**Jordan Springs Public School (SSD-9354)
Request for Additional Information**

Reference is made to the Response to Submissions (RtS) for Jordan Springs Public School (SSD-9354). After careful consideration, the Department is requesting that you provide additional information.

## PROPOSED SITE AND ROOF PLAN

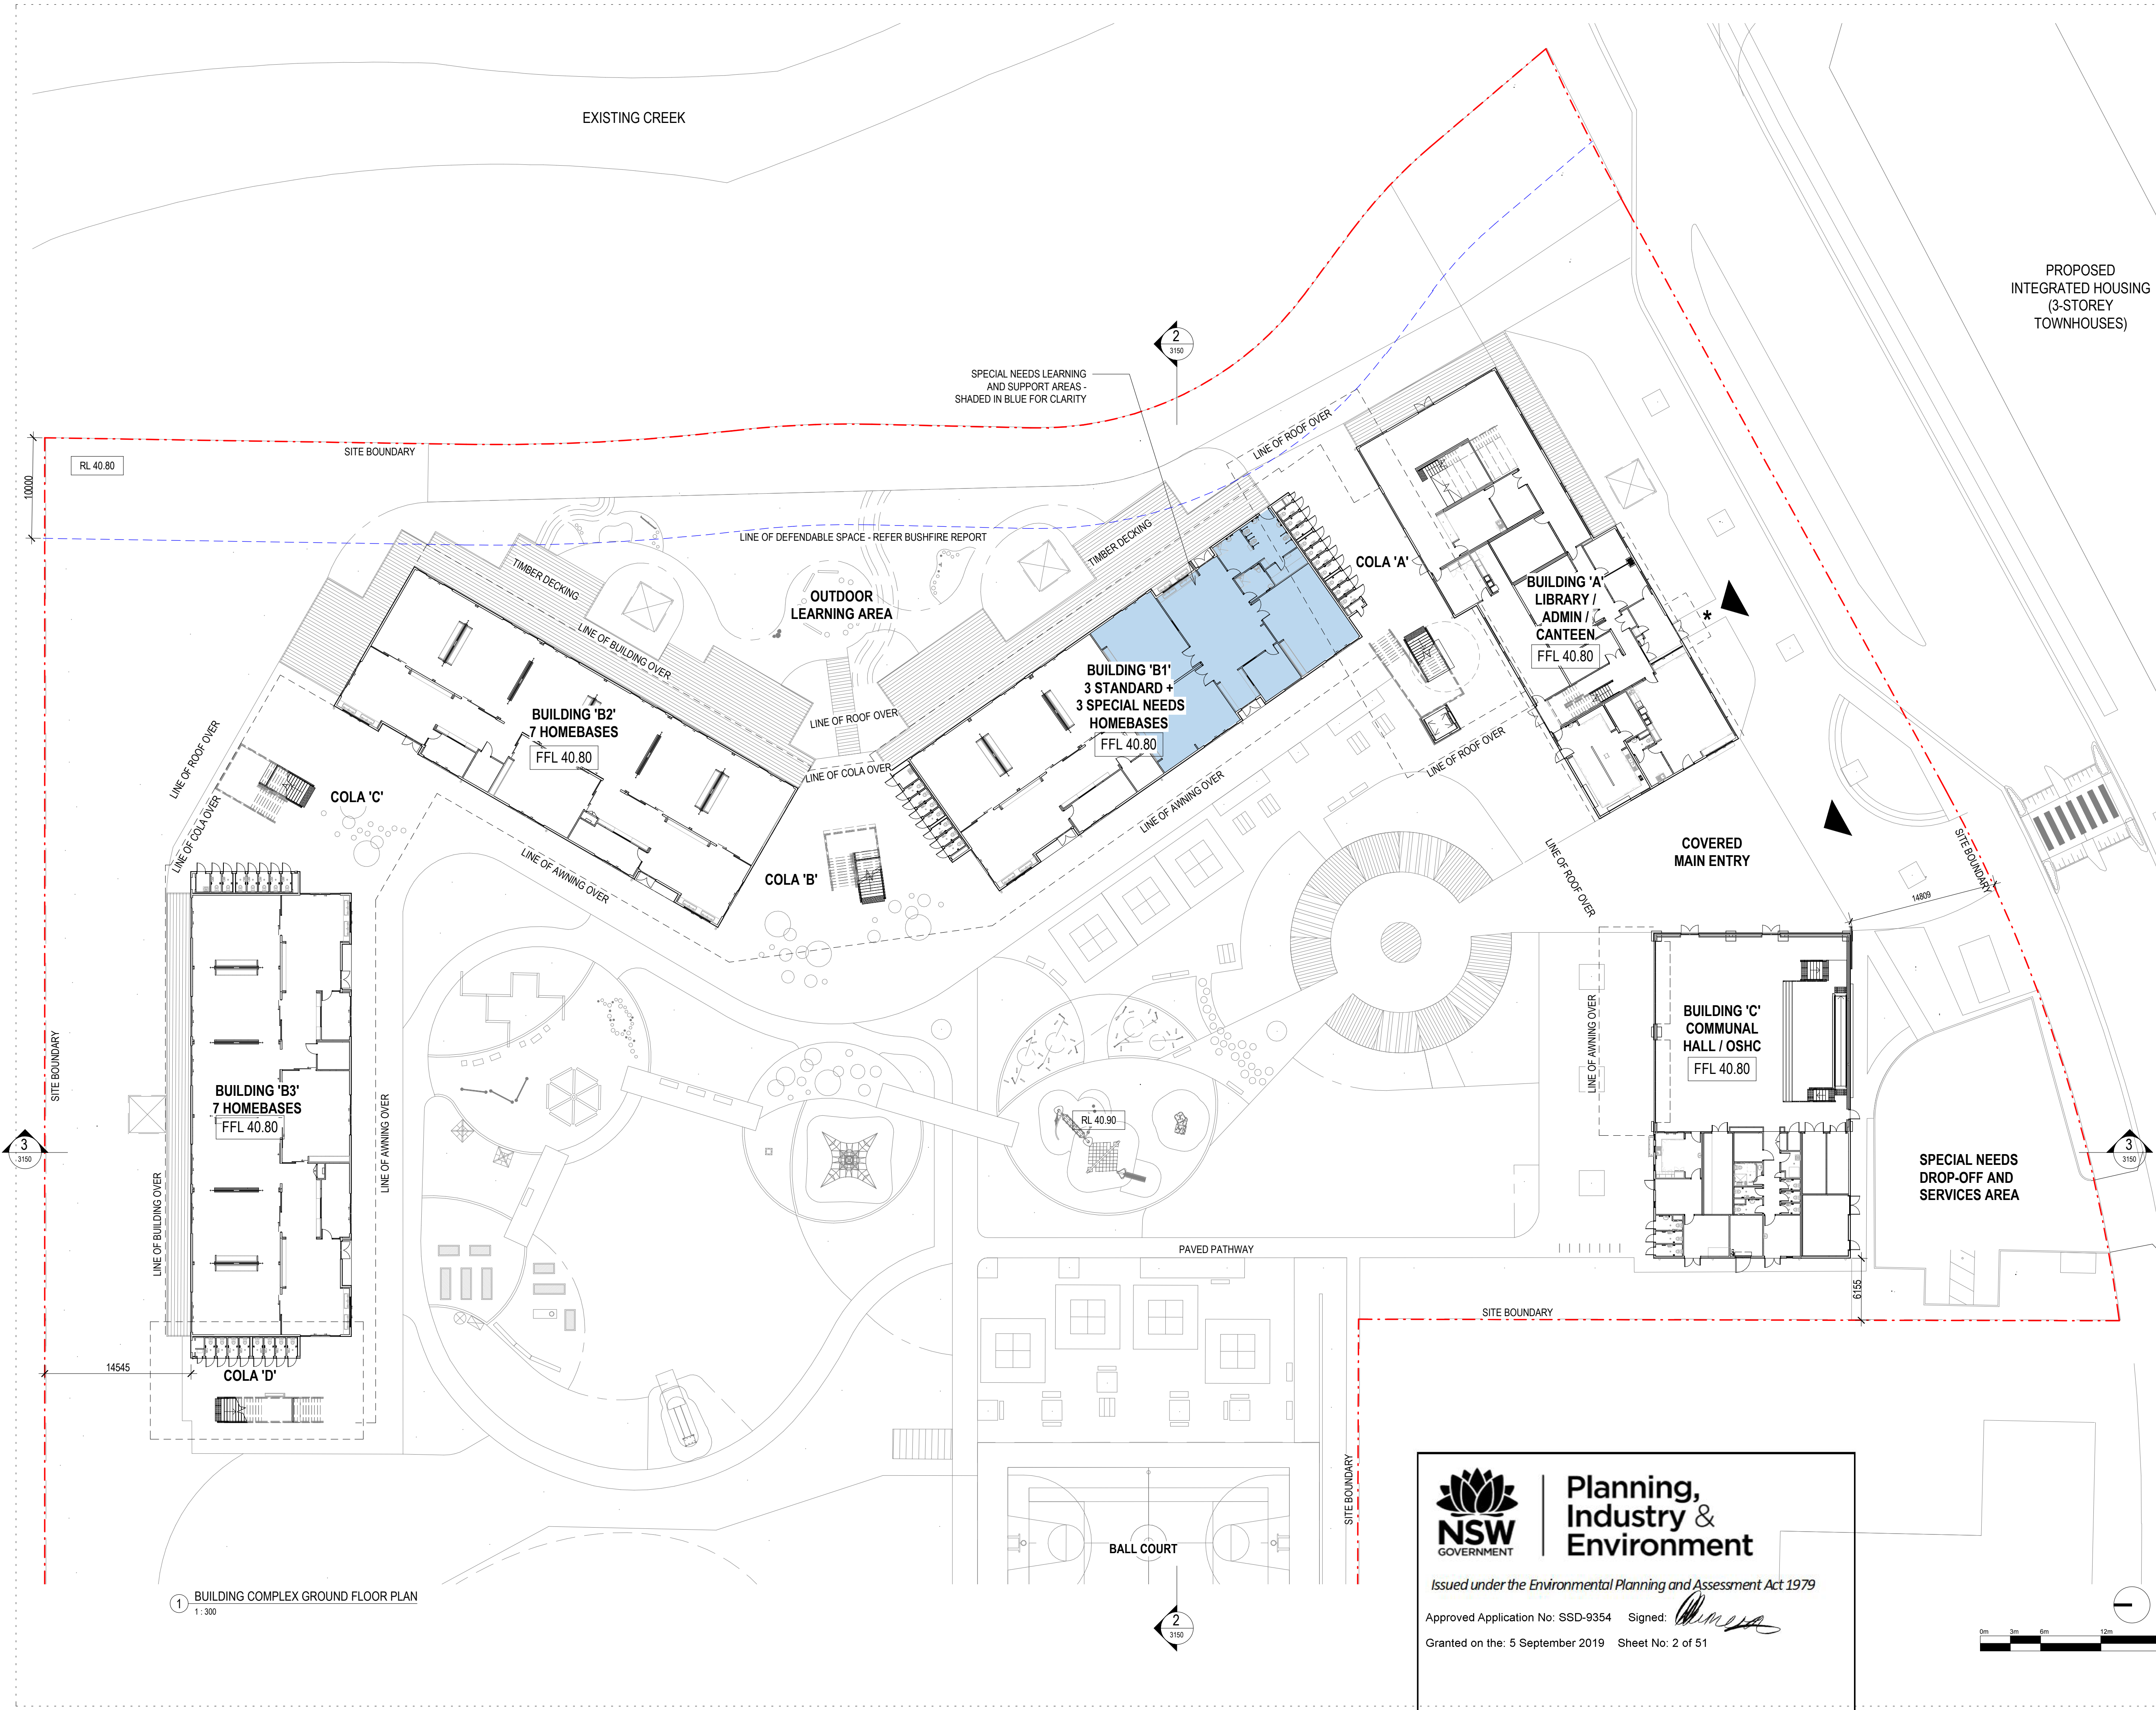
To improve amenity increased landscaping between the hall and Cullen Avenue car park is required.

Additionally, further information is required regarding the design of the proposed drop-off/pick-up zone along Cullen Avenue which is partly within the road reserve. Details should also be provided relating

to the redesign of the existing shared path and stormwater management adjacent to the proposed drop-off/pick-up zone.

**ROOF PLAN - COLA A**

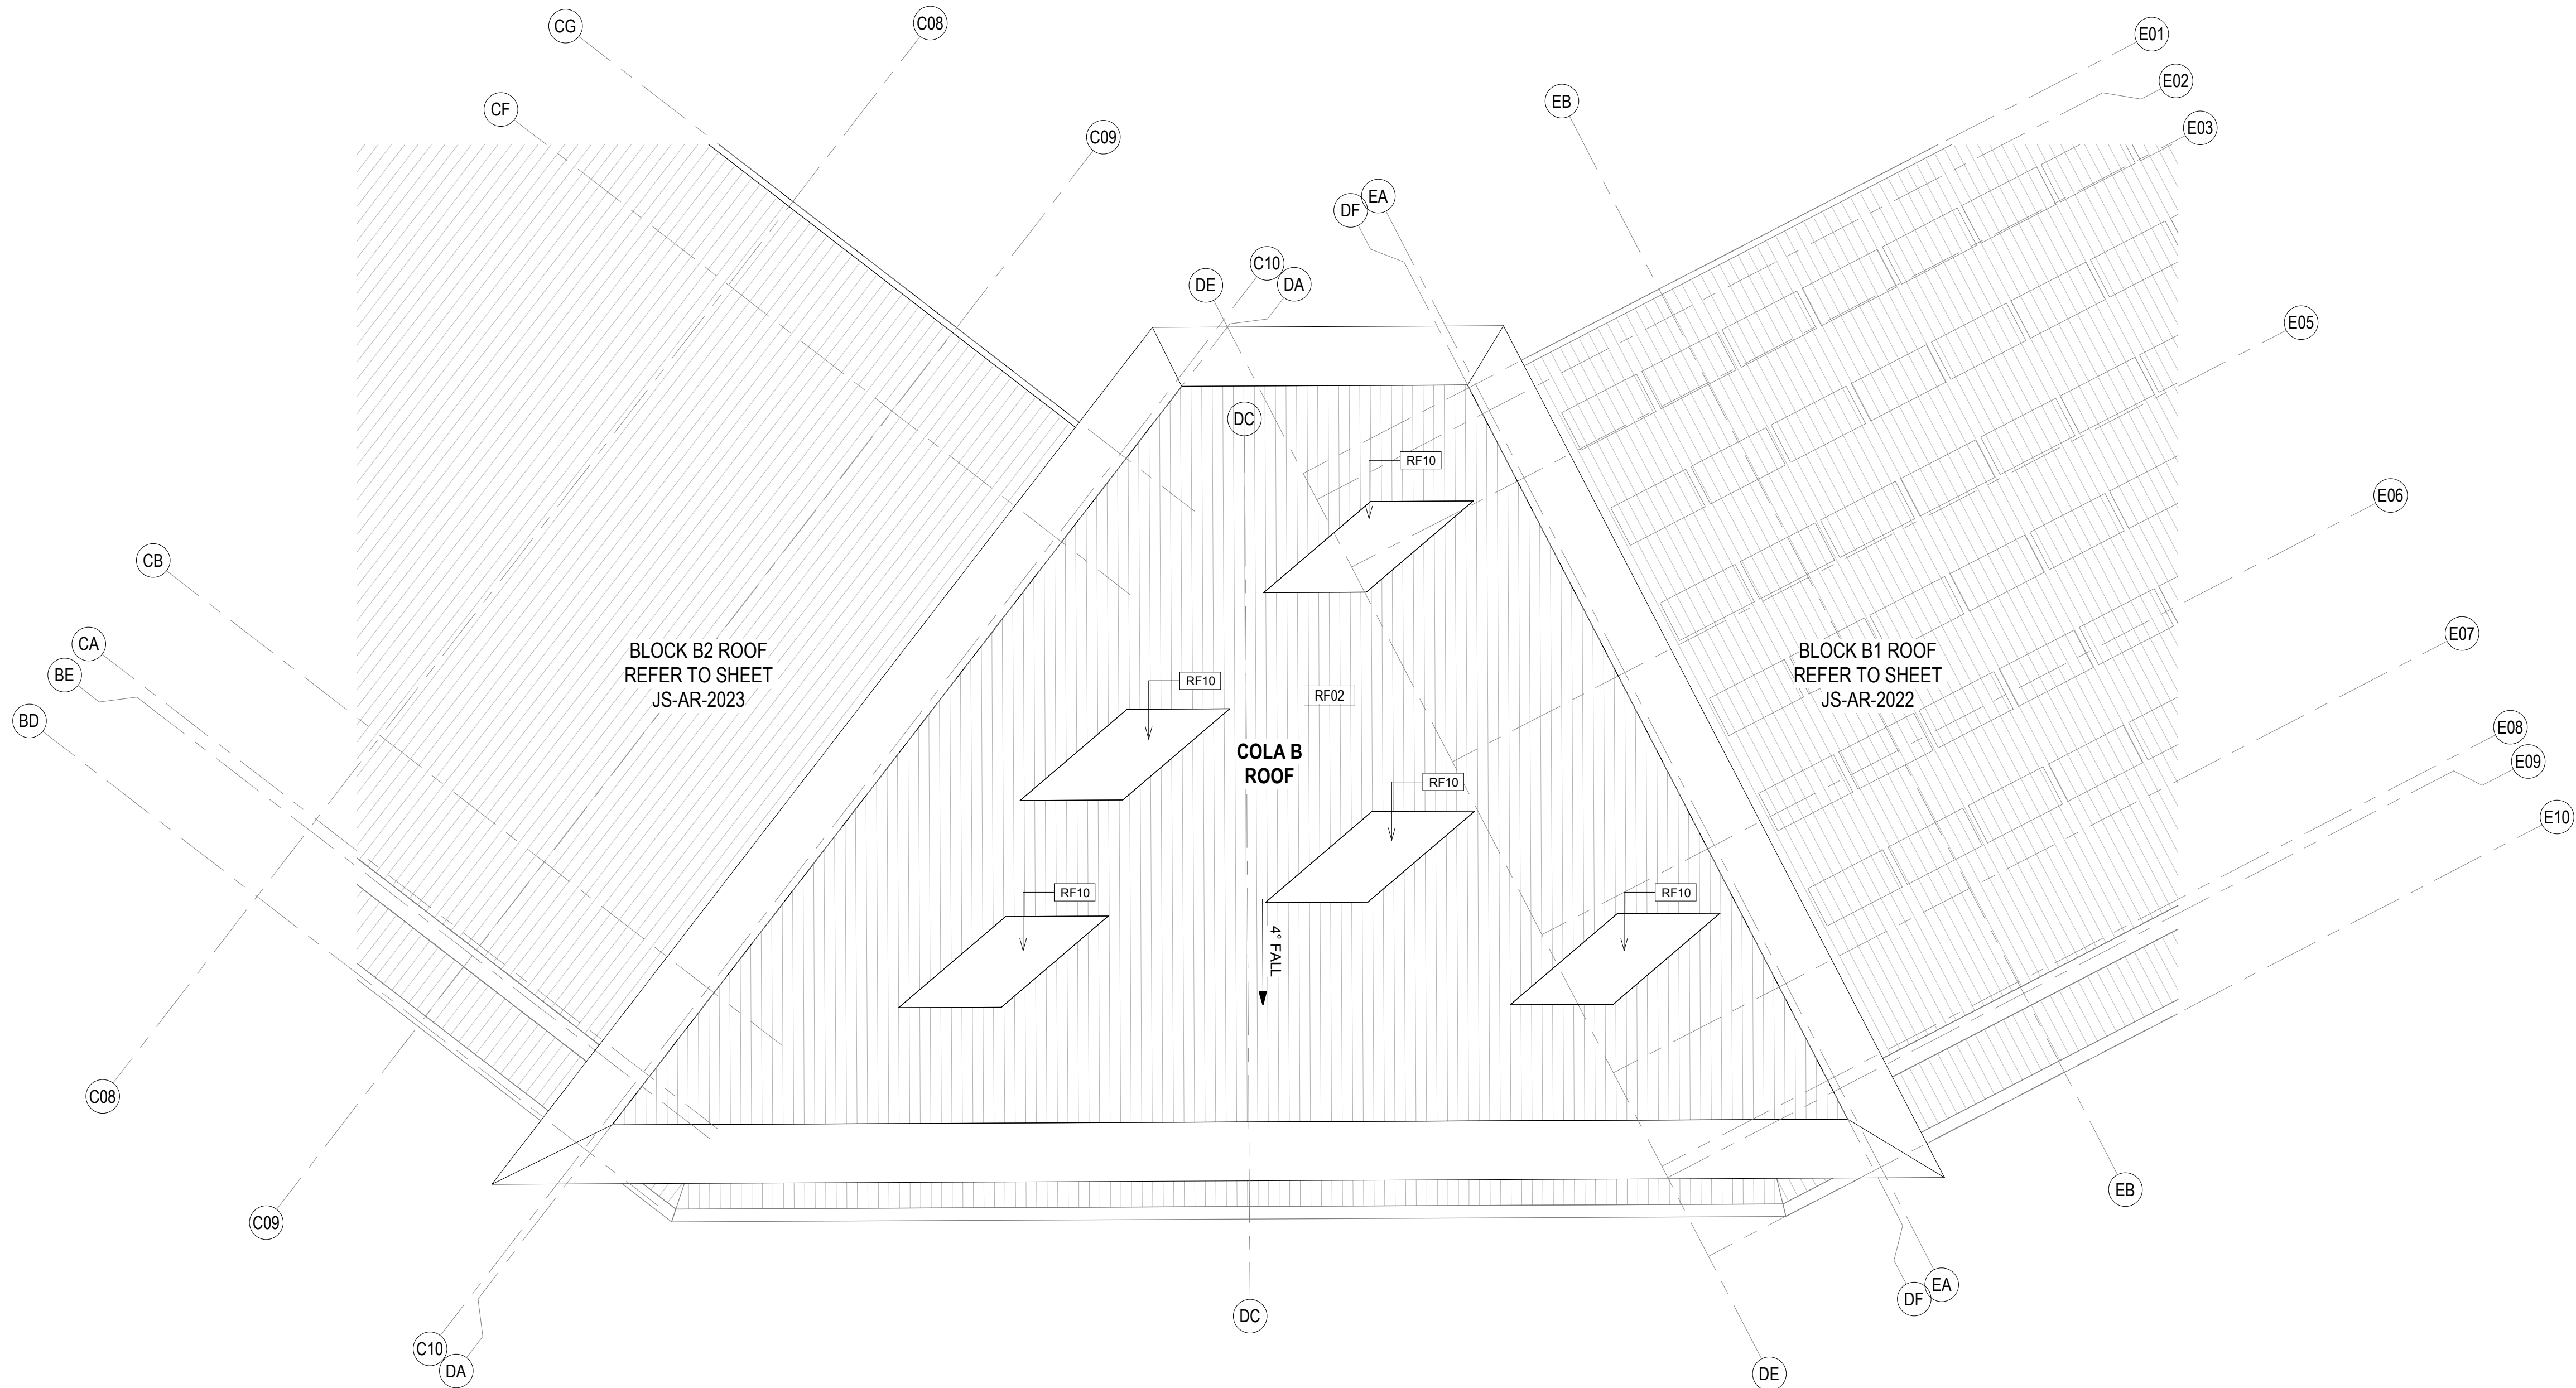
The Covered Outdoor Learning Area structures and walkway eaves lack construction credibility. Construction details, particularly through the edge condition should be provided.
